Council Ref: Kambala School (Trim Folder: SC5247 Ref: 20/223061)
Planning & Development Division

Woollahra
Municipal
Council

27 November 2020

Application Number SSD-10385
Proposal name Kambala sport, well-being and senior learning precinct – Kambala school
Address 794-796 New South Head Road, Rose Bay

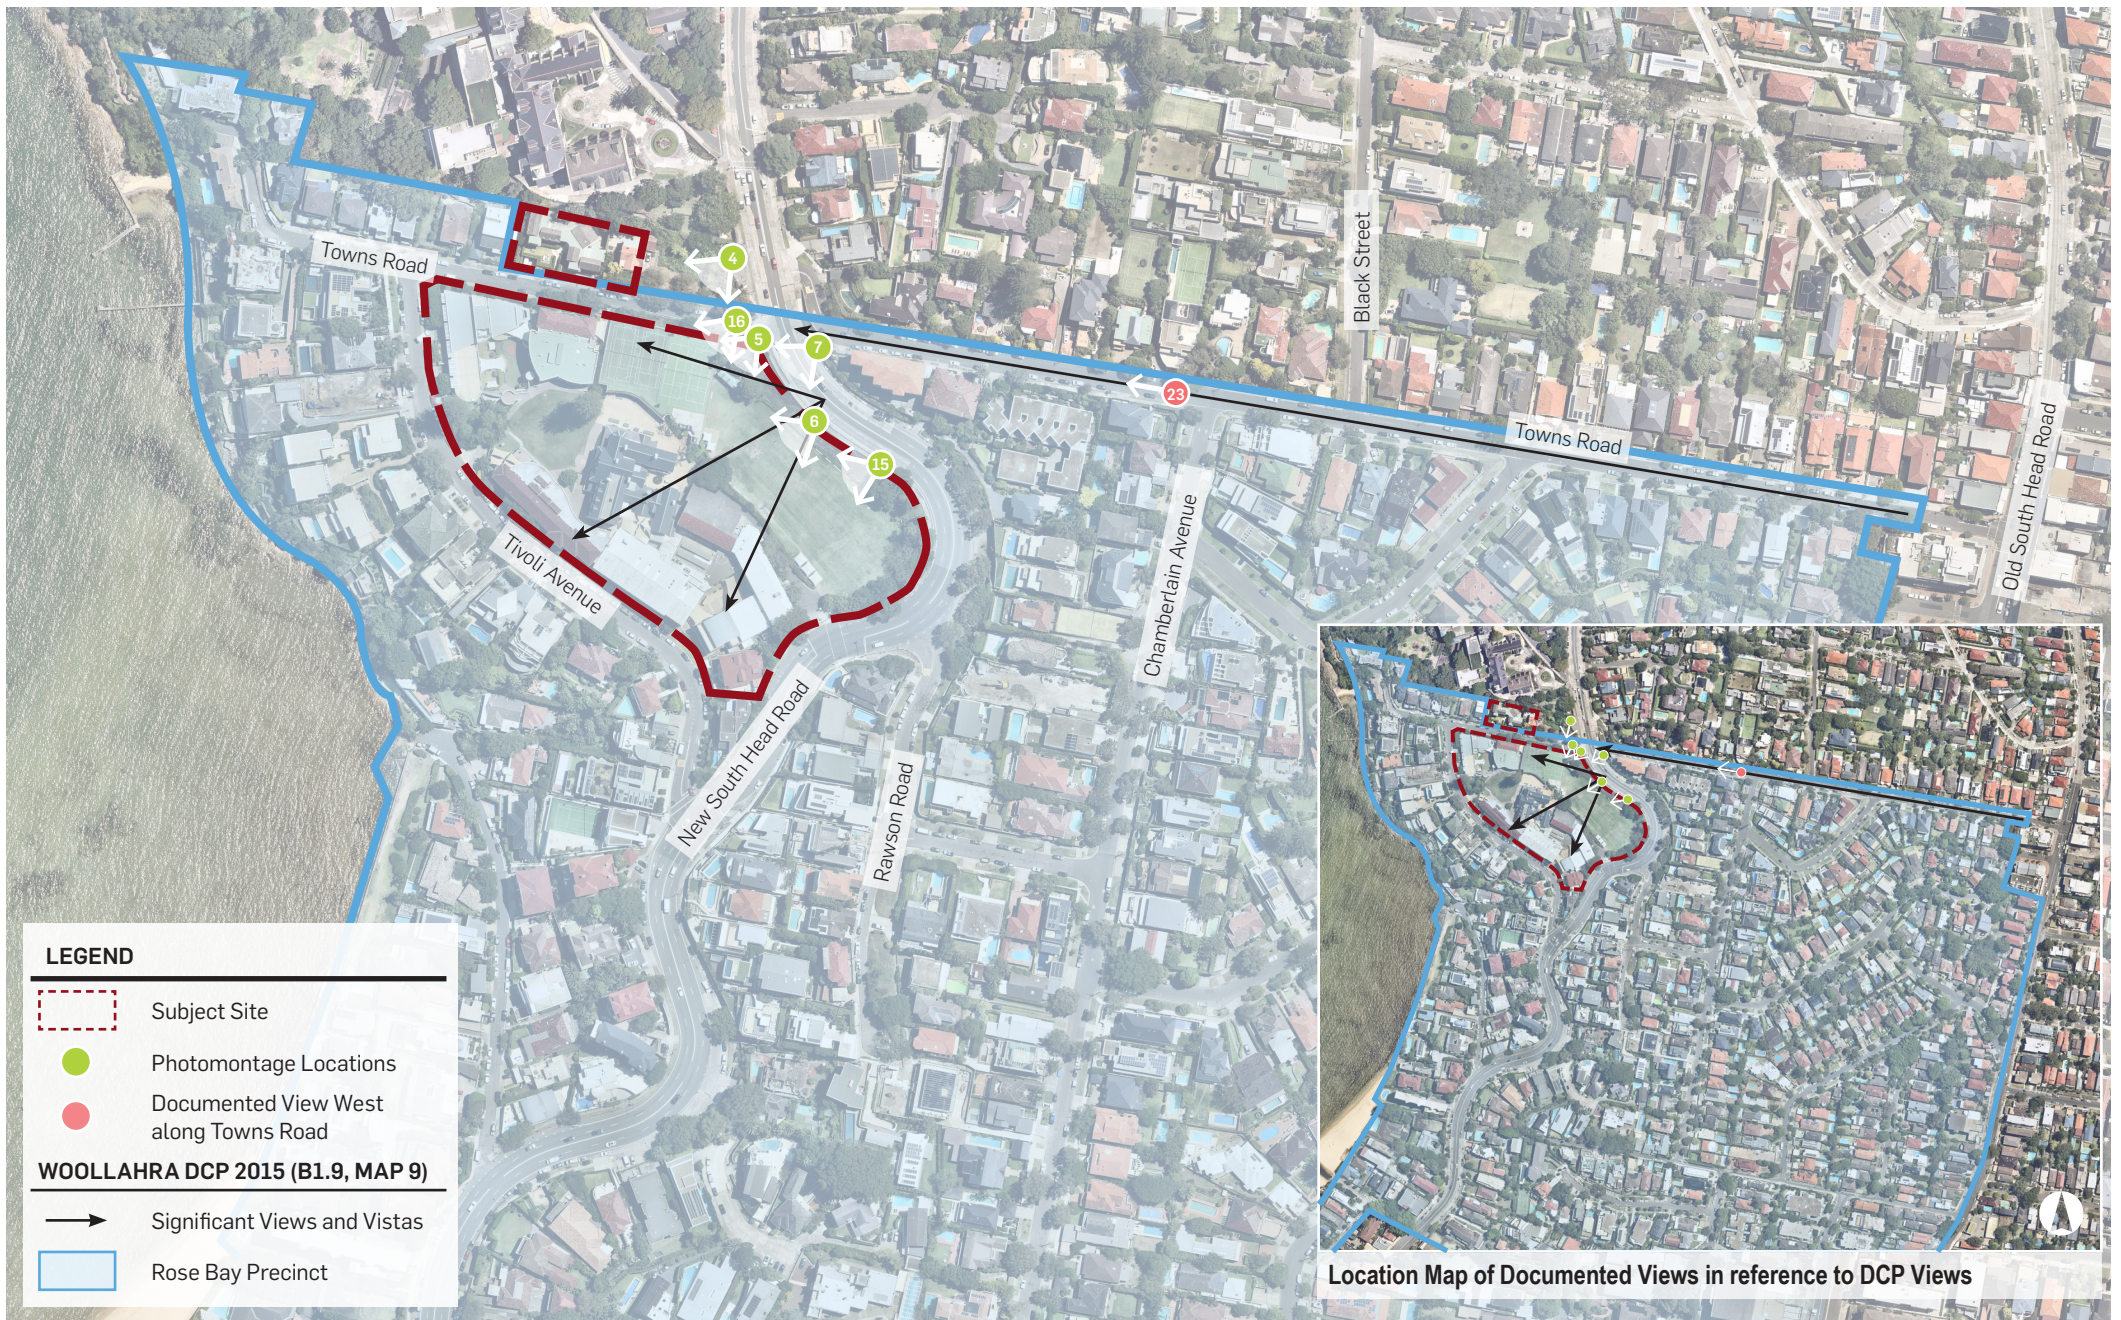
There are inconsistencies between the values attributed to the assessed views. In particular, the RLA report states that view impacts to Views 6, 9, 10, 15 and 16 would be 'high', and at View 5, the proposal would have 'medium' view impacts.

The impacts are described in the Urbis Report as 'acceptable' (page 2 of the Report) on the basis that the view impacts of the proposed development from close locations would be lower than the approved development for a Music Building (DA387/2005/1).

Section B1.9 of the Woollahra DCP 2015 identifies significant views and vistas across the Rose Bay Precinct. The views from Towns Street and New South Head Road towards Sydney Harbour are relevant to this proposal, and have not been addressed. It is unclear which assessed view is equivalent to the DCP view corridor from Towns road. It is recommended that further information is requested by DPIE in relation to this issue in order to carry out a proper assessment.

The proposed bulk and scale at View locations 5, 6, 15 and 16 would largely block the existing views from New South Head Road to the Tivoli Heritage Building. Views 6 and 15 are in similar locations/equivalent to the identified views by Woollahra DCP 2015 B1.9. According to the DCP, these are 'significant' views and vistas. The proposal has high visual impacts on the public views achieved from these locations, eliminating the visibility of the heritage building when viewed from New South Head Road. This is inconsistent with the following provisions of Woollahra DCP 2015:

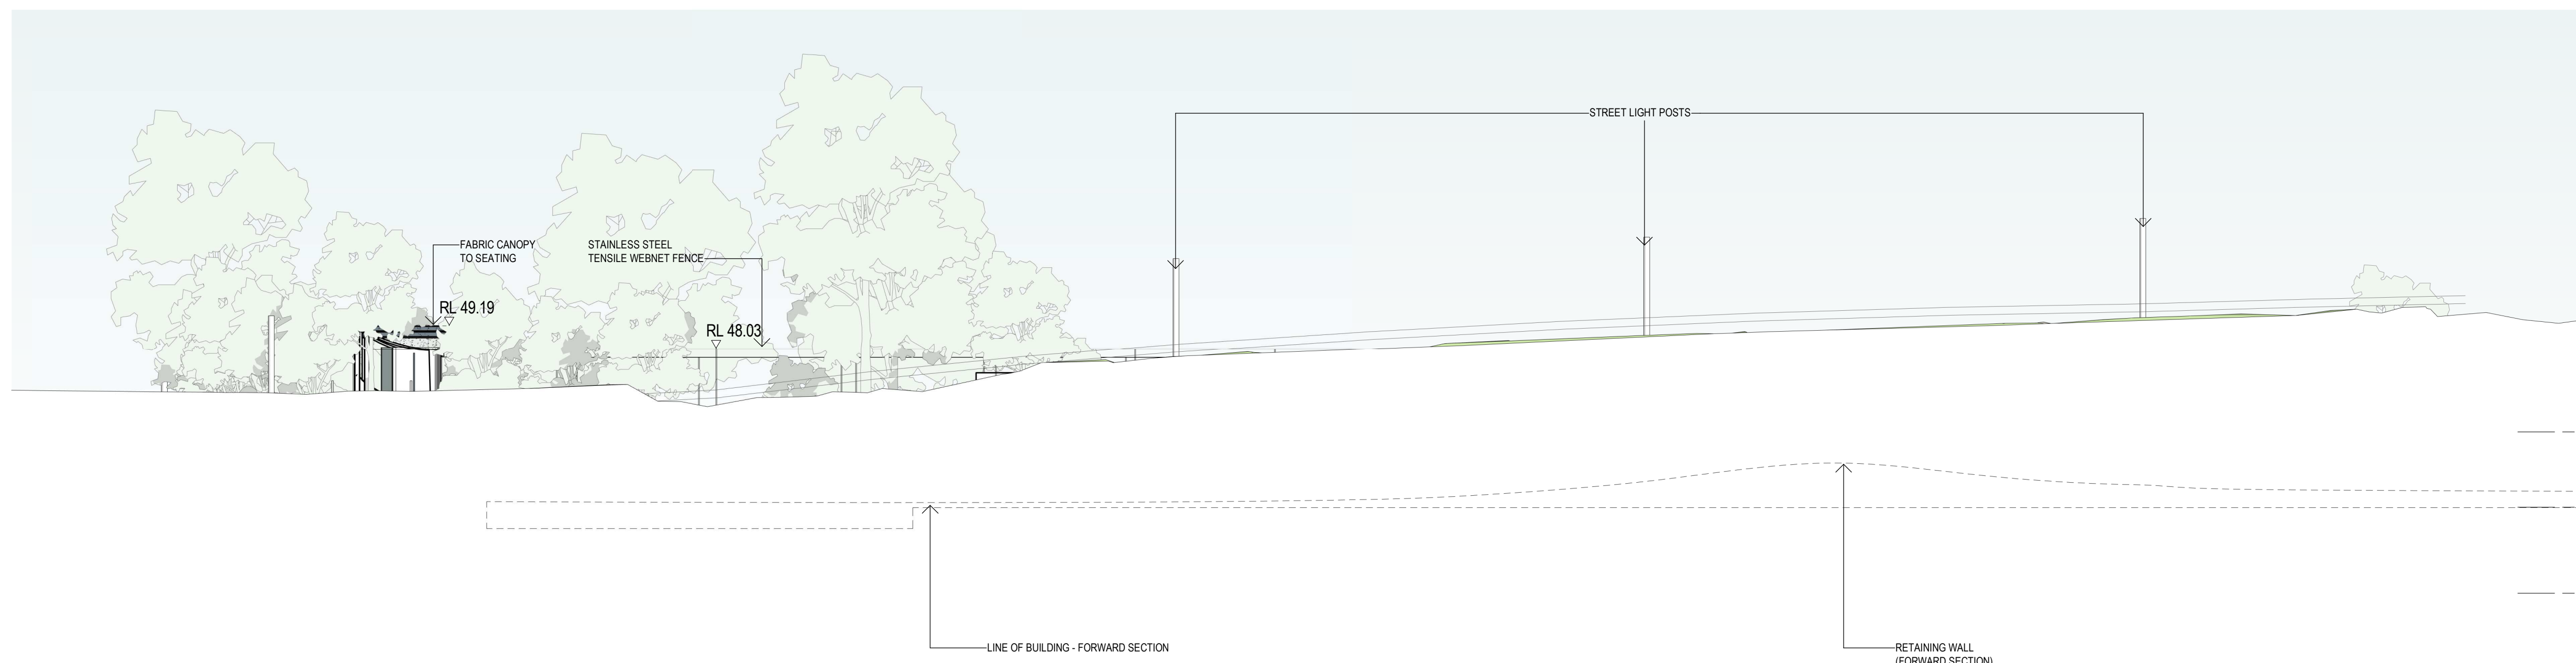
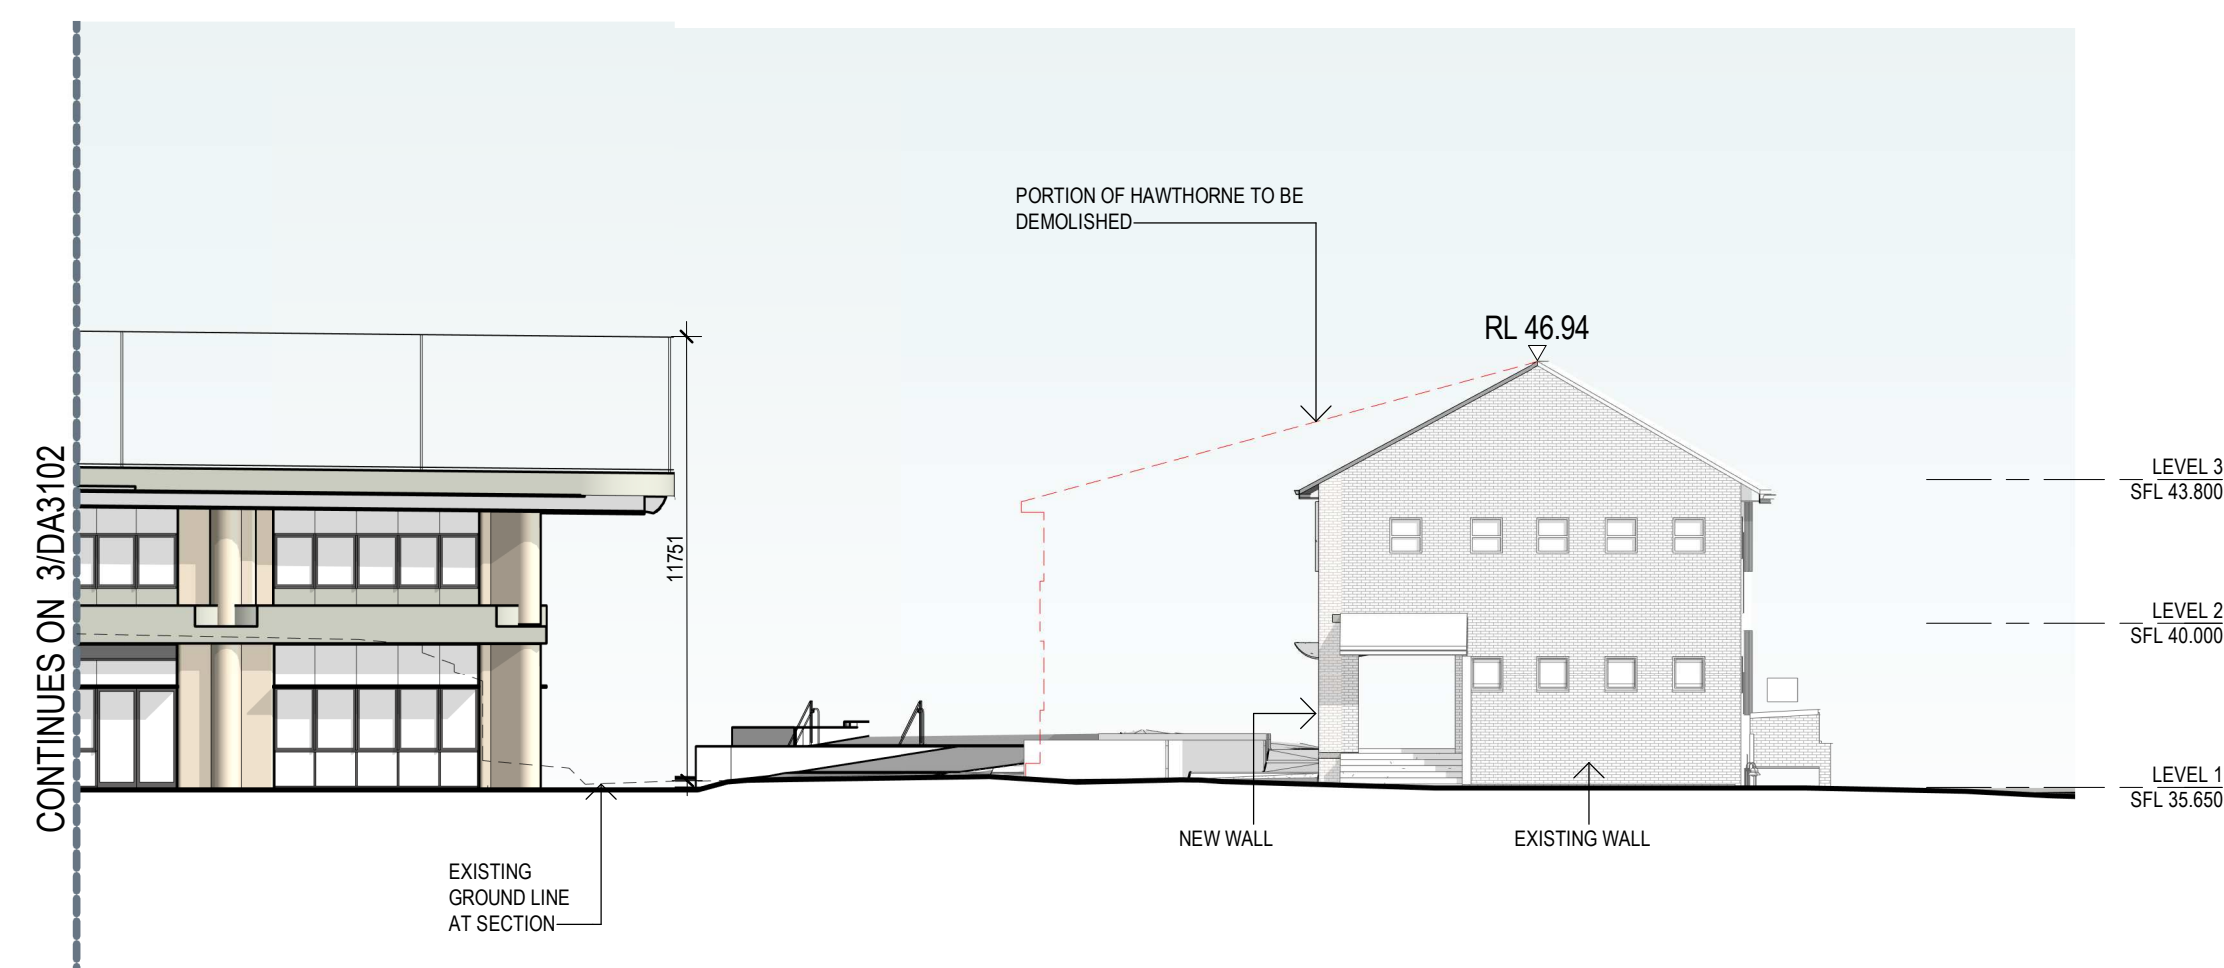
Insufficient details of the infrastructure/amenities requirements such as lighting, furniture, nets and fencing that would be required to service sporting facilities of this nature have been provided. This may further impact upon existing significant views. Details are required to enable a proper assessment.
